## Response to Comments 1342 Congress Street - Proposed Neighborhood Center

**To:** Jean Fraser, Planner; City of Portland  
**FROM:** Greg Halsey, Tighe & Bond, Inc.  
**CC:** Steve Brinn, Jewish Community Alliance of Southern Maine  
**DATE:** May 8, 2015

**A. Reviewer: David Senus, P.E. Woodard & Curran  
Date: May 1, 2015**

SCALE:	AS SHOWN
C-9	
DETAILS SHEET	
APPROVED BY:	BLM
CHECKED:	BLM
DRAWN BY:	GWH
PROJECT NO.:	J-0096
FILE:	J0096-DETAILS.dwg
DATE:

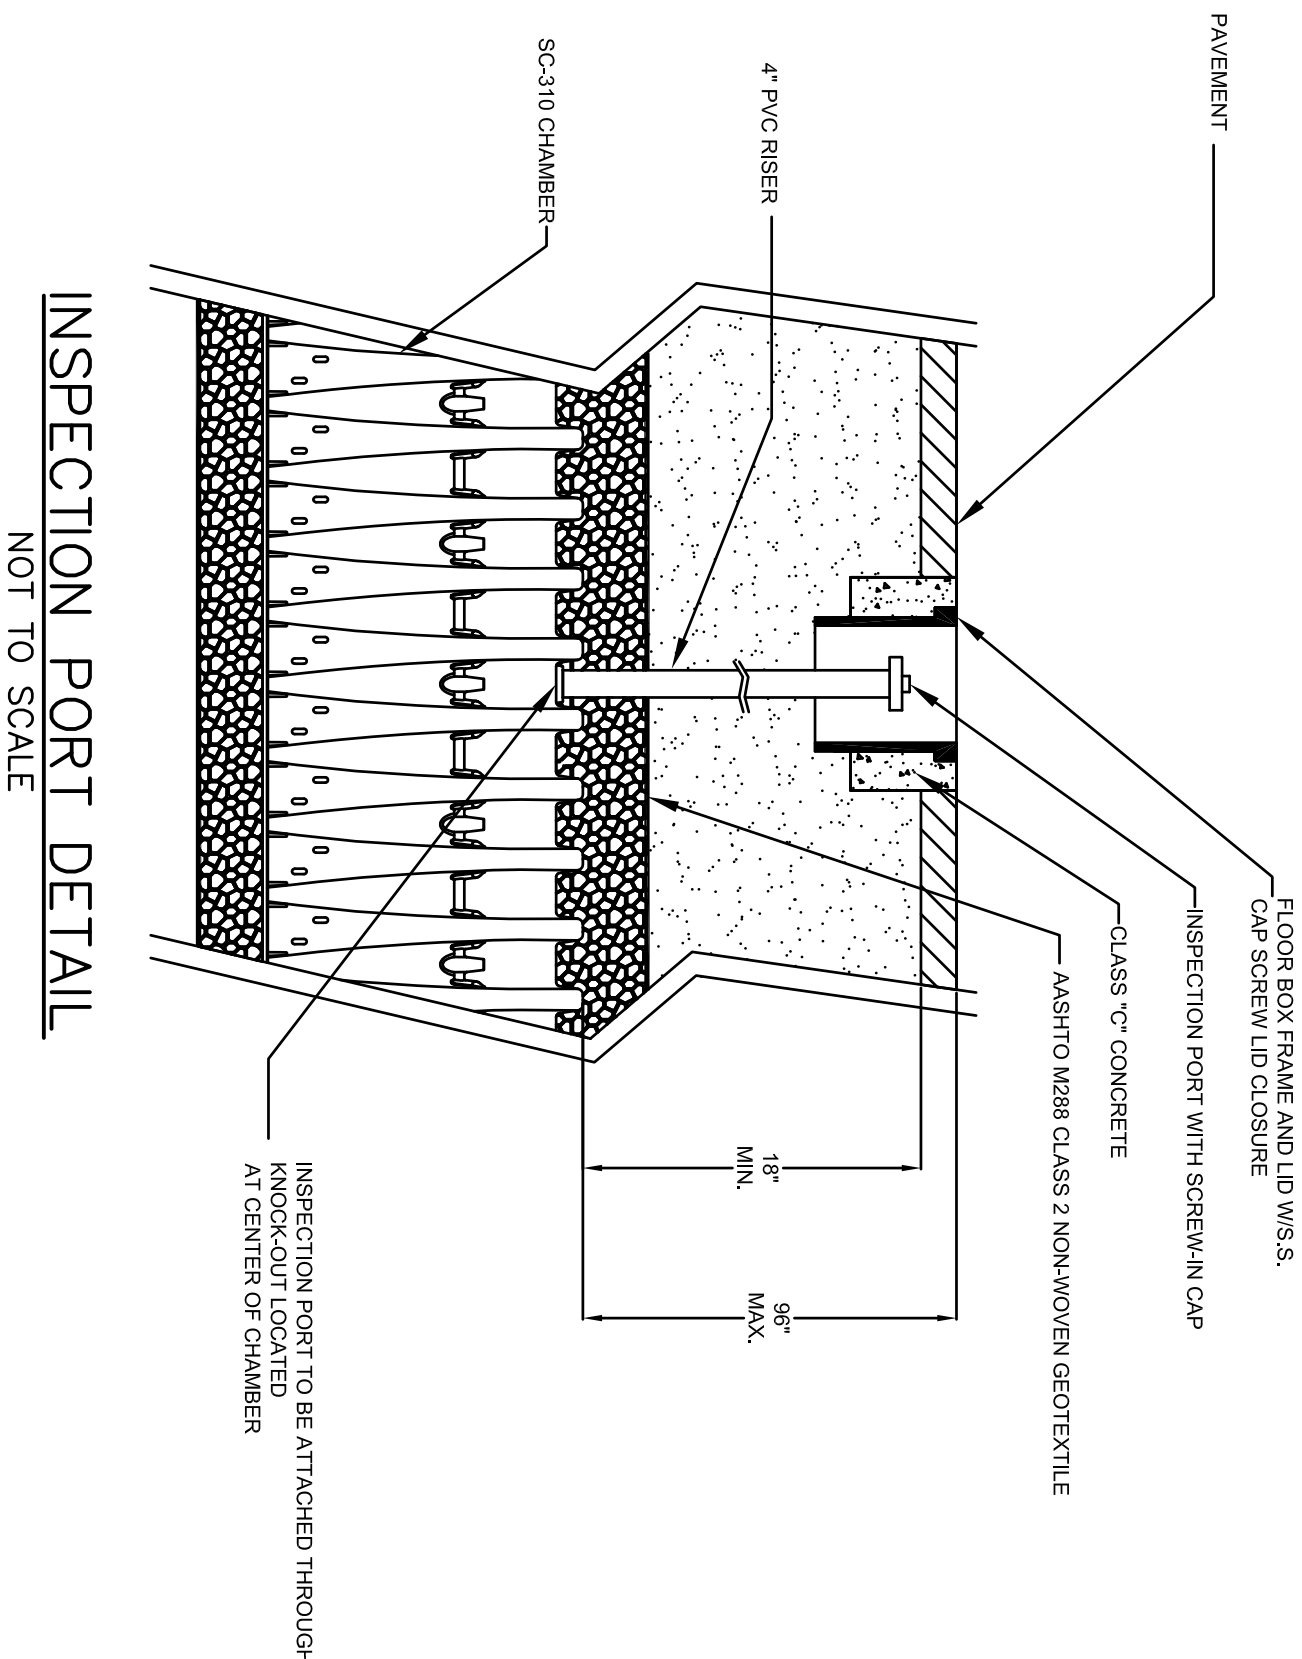
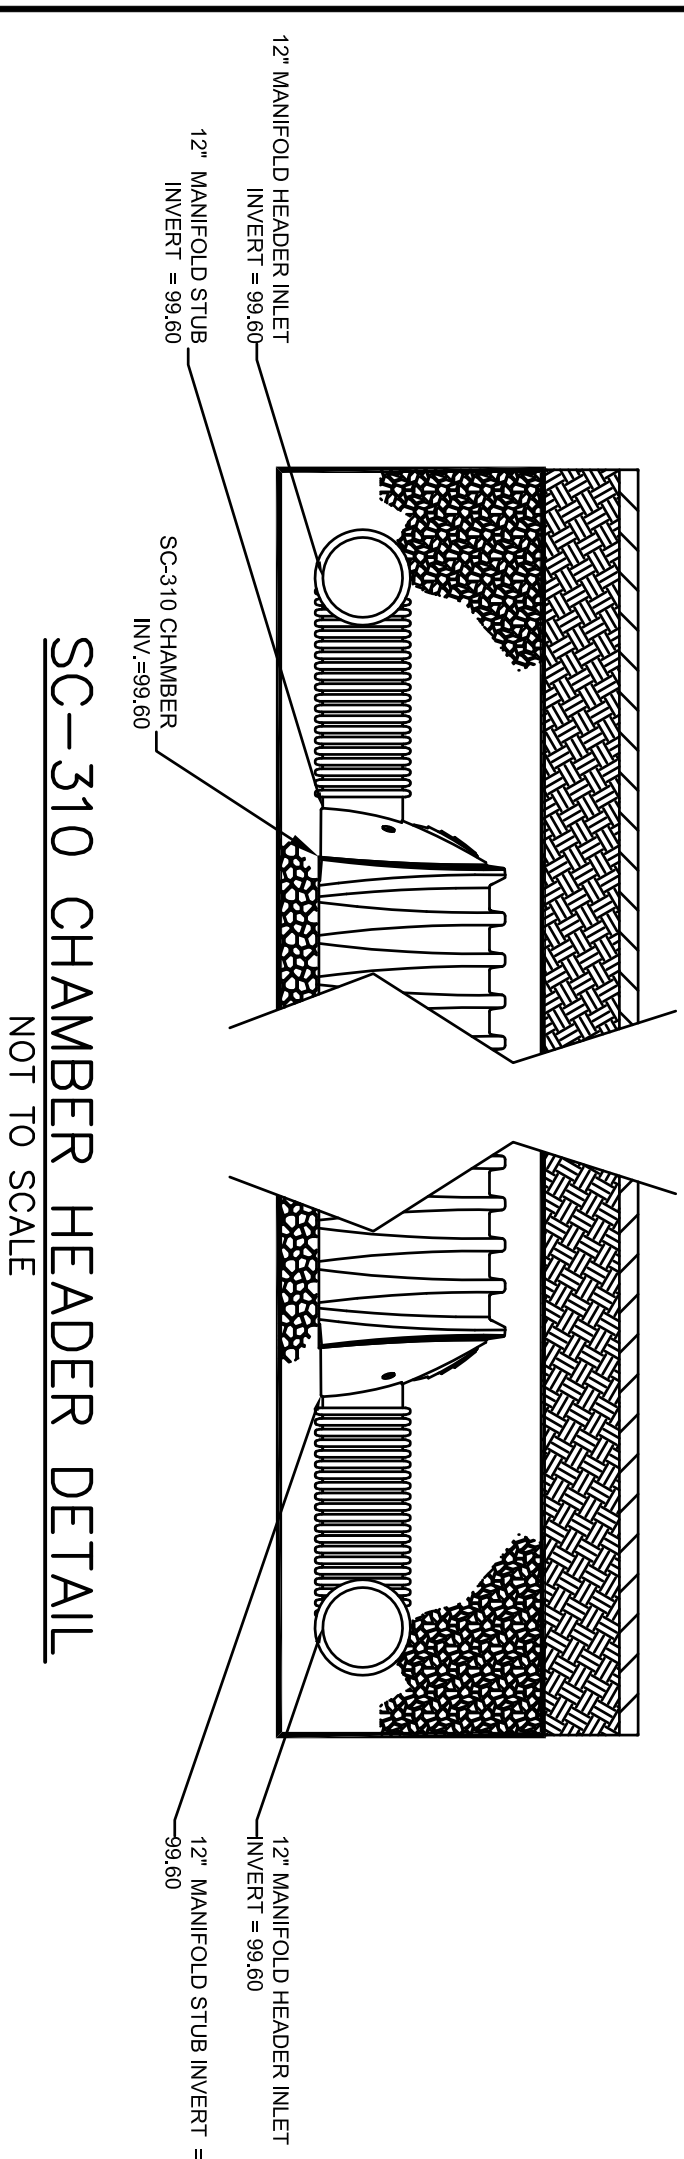
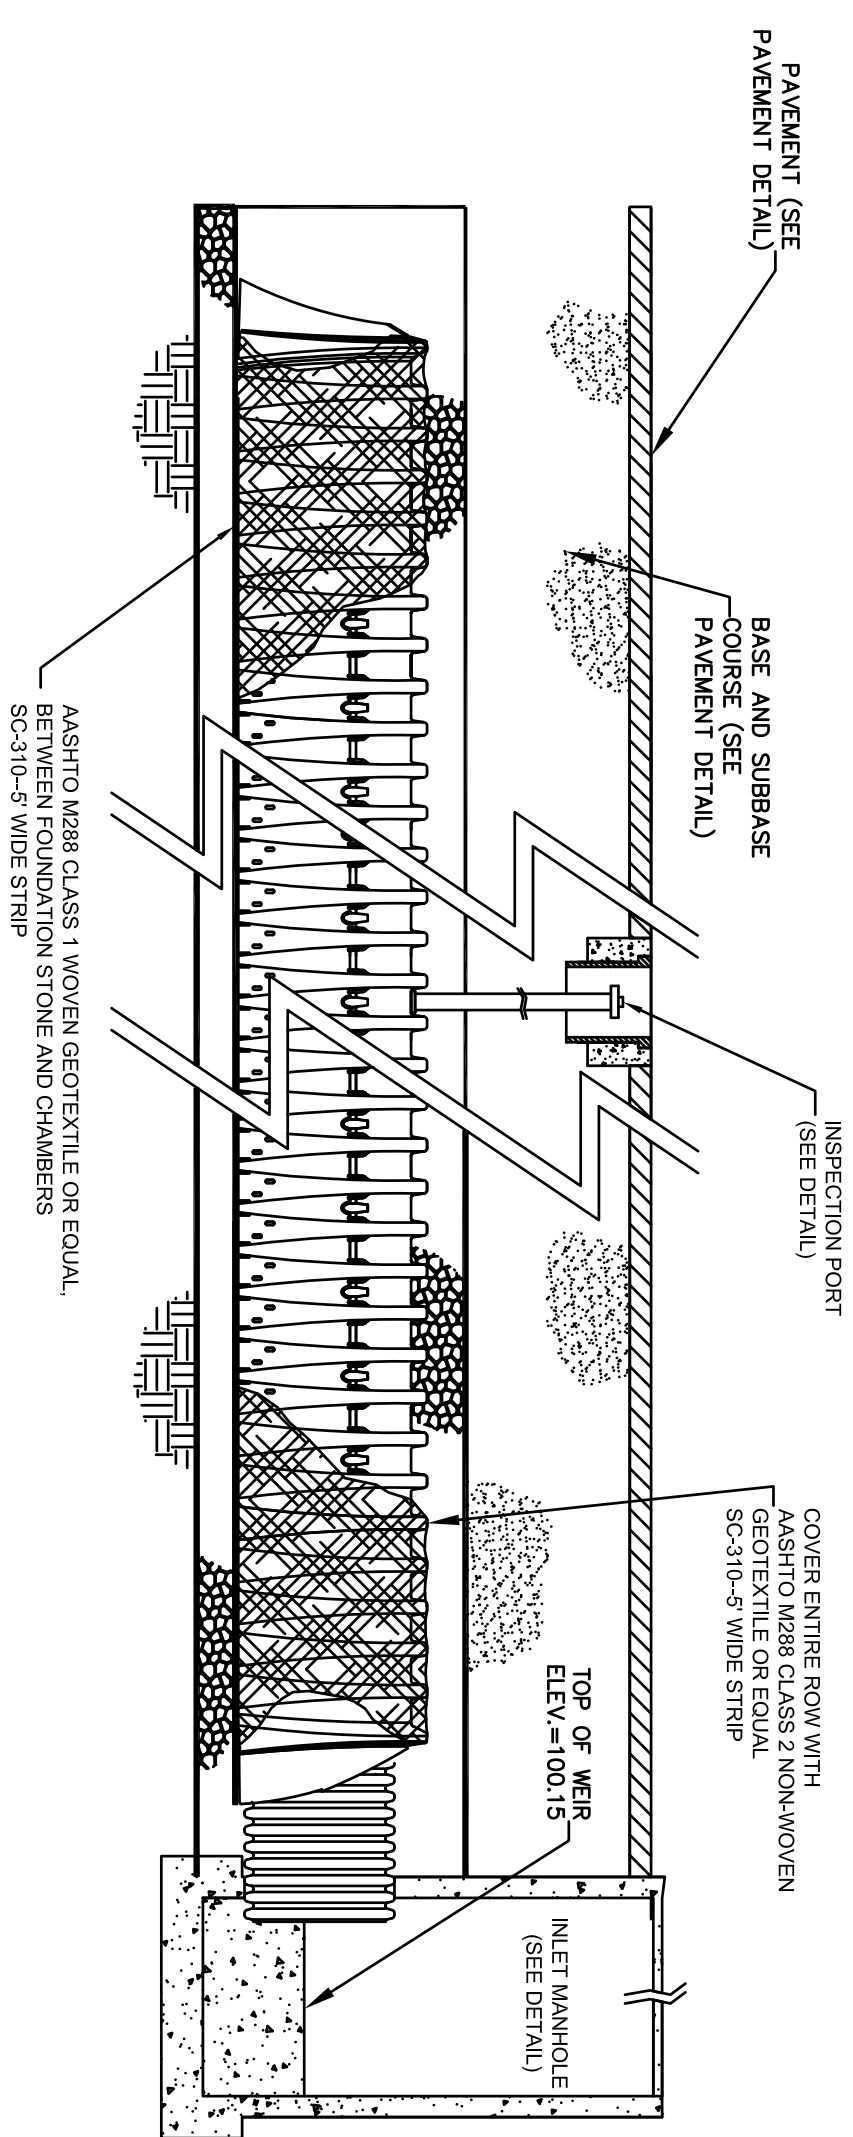
- ii) Future submittals should include details for the outlet control structures associated with the soil filter and the StormTech Chamber system, including orifices and weirs.*

- iii) *Future submittals should identify key elevations for the StormTech Chamber detail matching to the elevations utilized in the HydroCAD model.*

**Details of the outlet control structures for the soil filter and**

**StormTech Chambers have been provided. See Sheets C-7/C-9, Details Sheets, provided with this response.**

**Key elevations for the StormTech Chamber have been provided on Sheet C-9. Revised HydroCAD calculations with corresponding elevations have been included in the revised Drainage Study.**
